**KIRKLEES COUNCIL
TOWN AND COUNTRY PLANNING ACT 1990
HIGHWAYS DEVELOPMENT MANAGEMENT**

PLANNING REF 2017/62/90769/W0/LY
CATEGORY Minor

PROPOSAL ERECTION OF DETACHED
DWELLING

LOCATION ADJ FIELDHEAD
HILL LANE
HOLMFIRTH
HD9 3BW

Drawing Number:
16-144-10

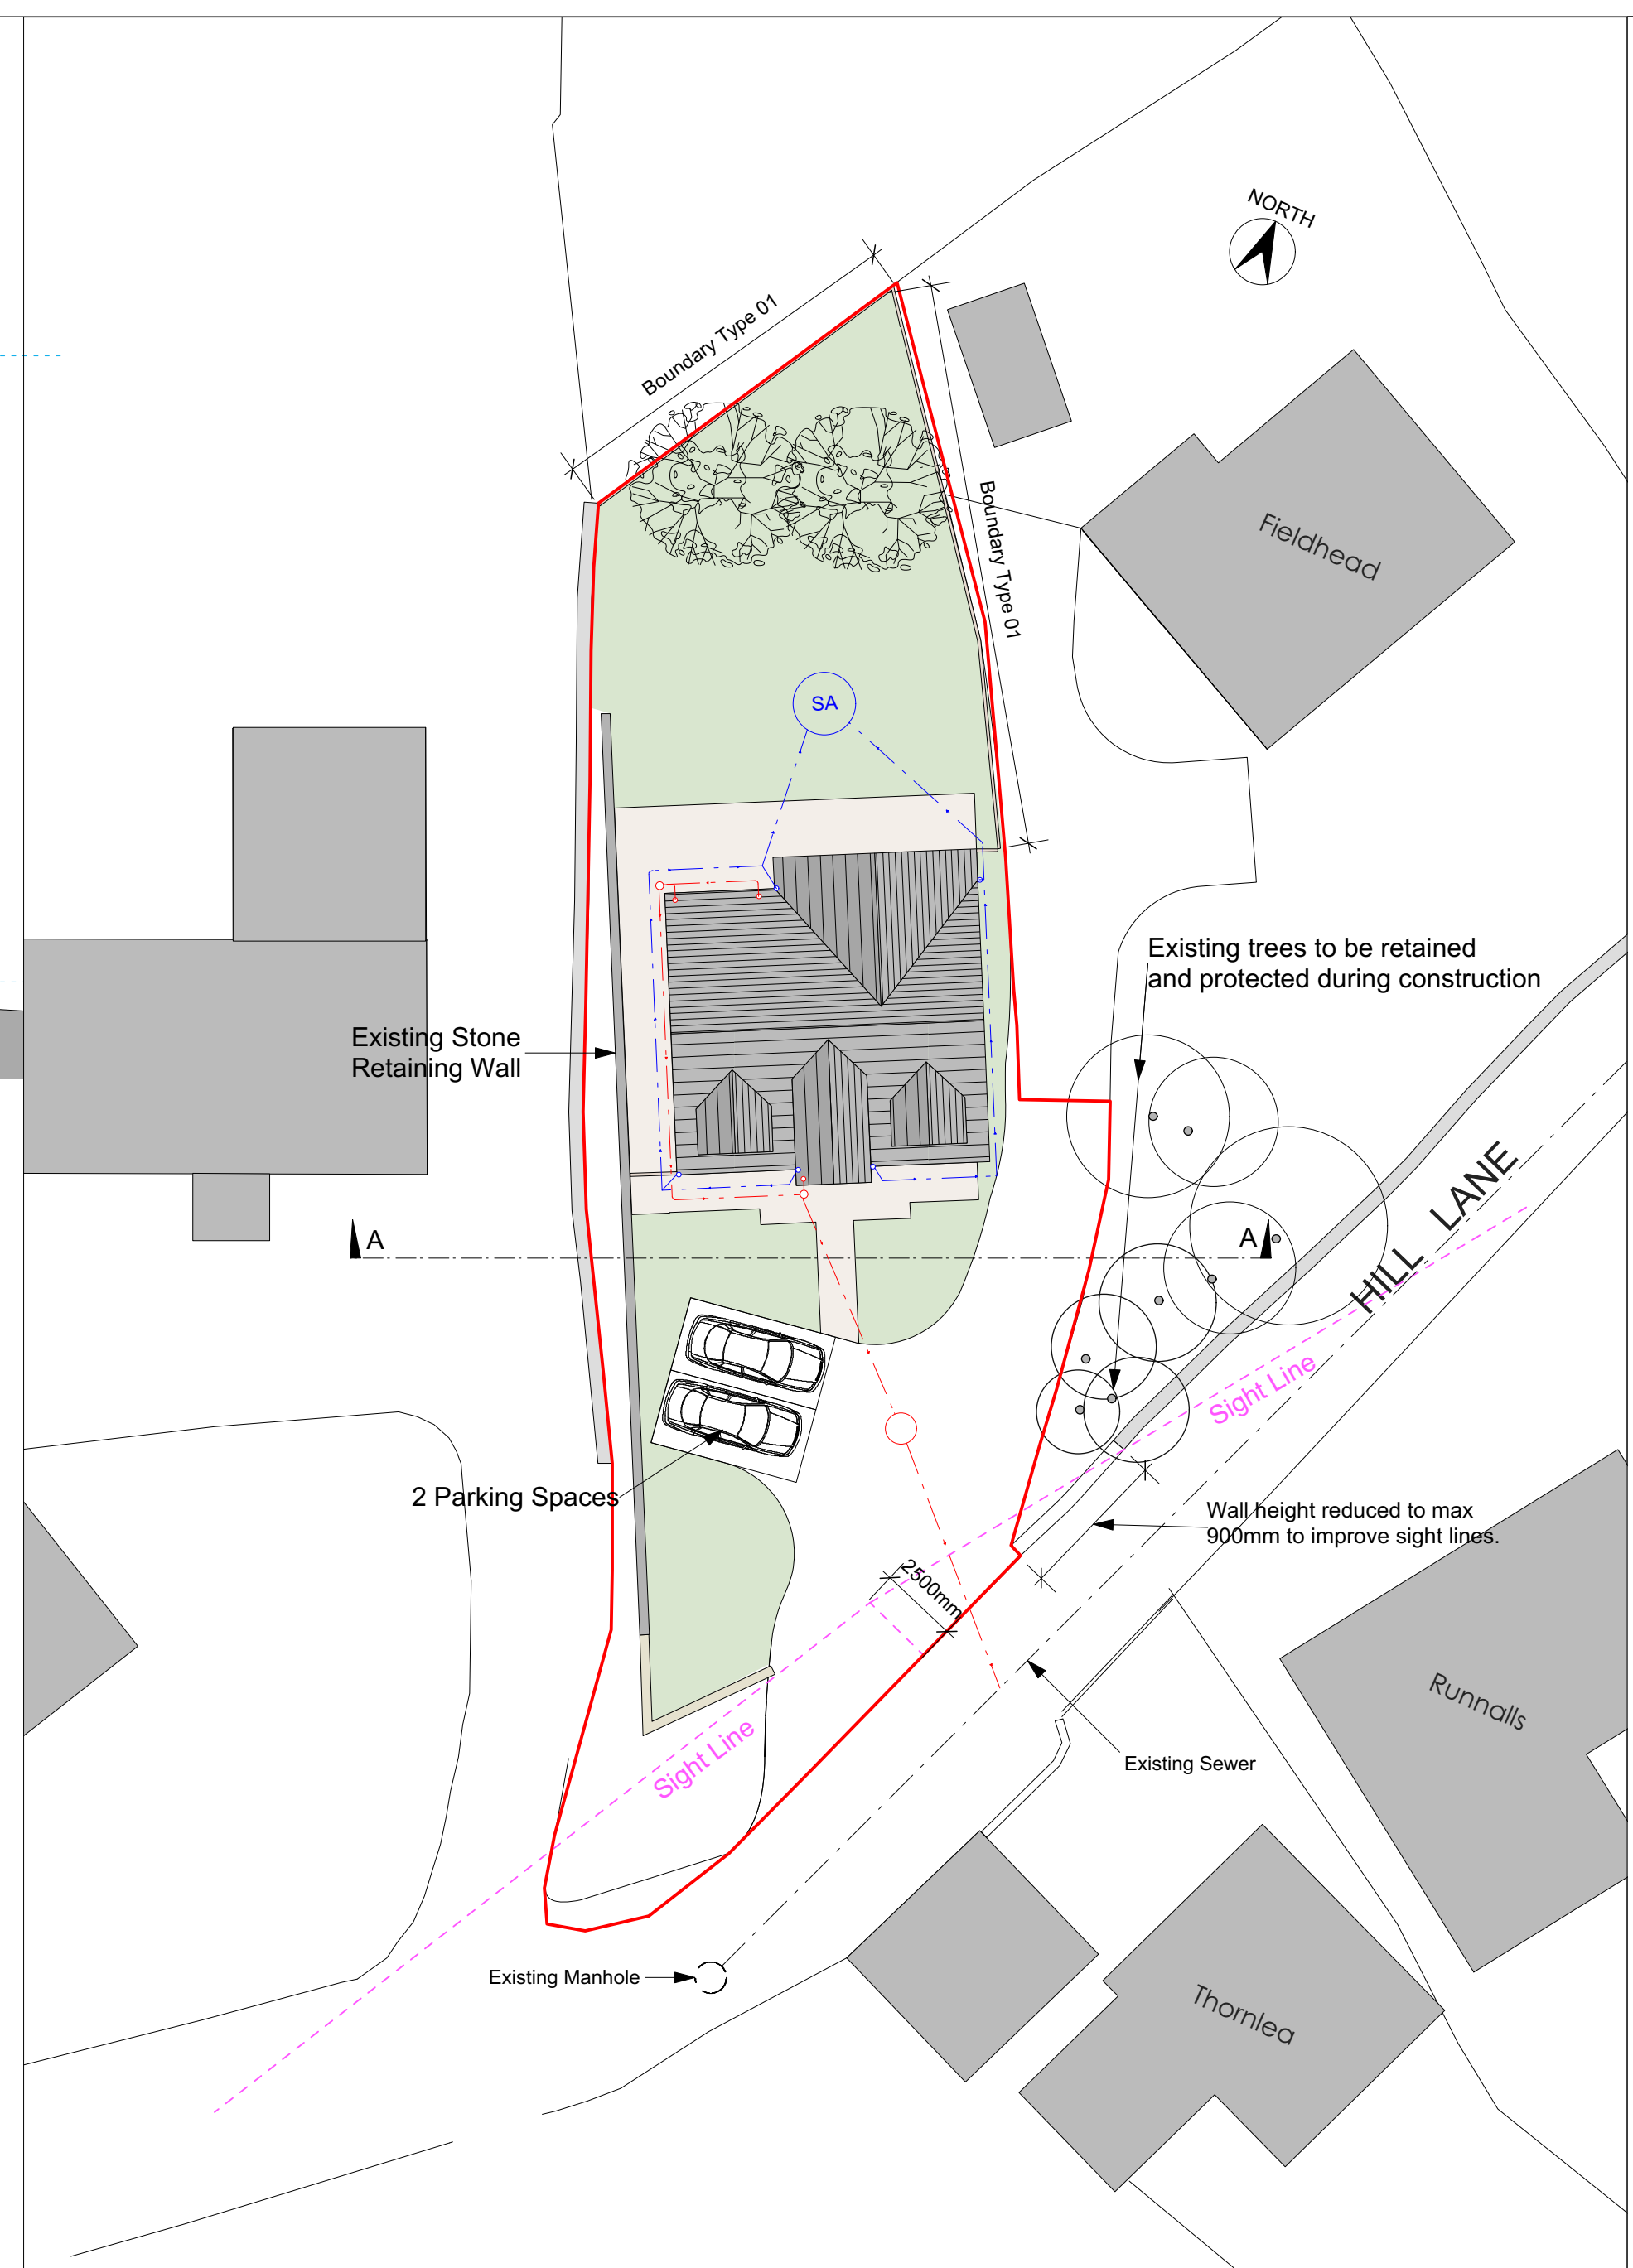
The current proposal provides a similar access and sight lines to the previous approval. Two off-street parking spaces and internal turning are also to be provided.

These proposals are considered acceptable from a highways point of view and Highways DM has no wish to resist the granting of planning permission.

Access Sightlines to be provided

Prior to the development being brought into use, the sightlines as shown on approved plan number 16-144-10 shall be cleared of all obstructions to visibility exceeding 0.9 m in height and these shall be retained free of any such obstruction.

Areas to be surfaced and drained

Prior to the development being brought into use, the approved vehicle parking areas shall be surfaced

and drained in accordance with the Communities and Local Government; and Environment Agencies 'Guidance on the permeable surfacing of front gardens (parking areas)' published 13th May 2009 (ISBN 9781409804864) as amended or superseded; and thereafter retained throughout the lifetime of the development.
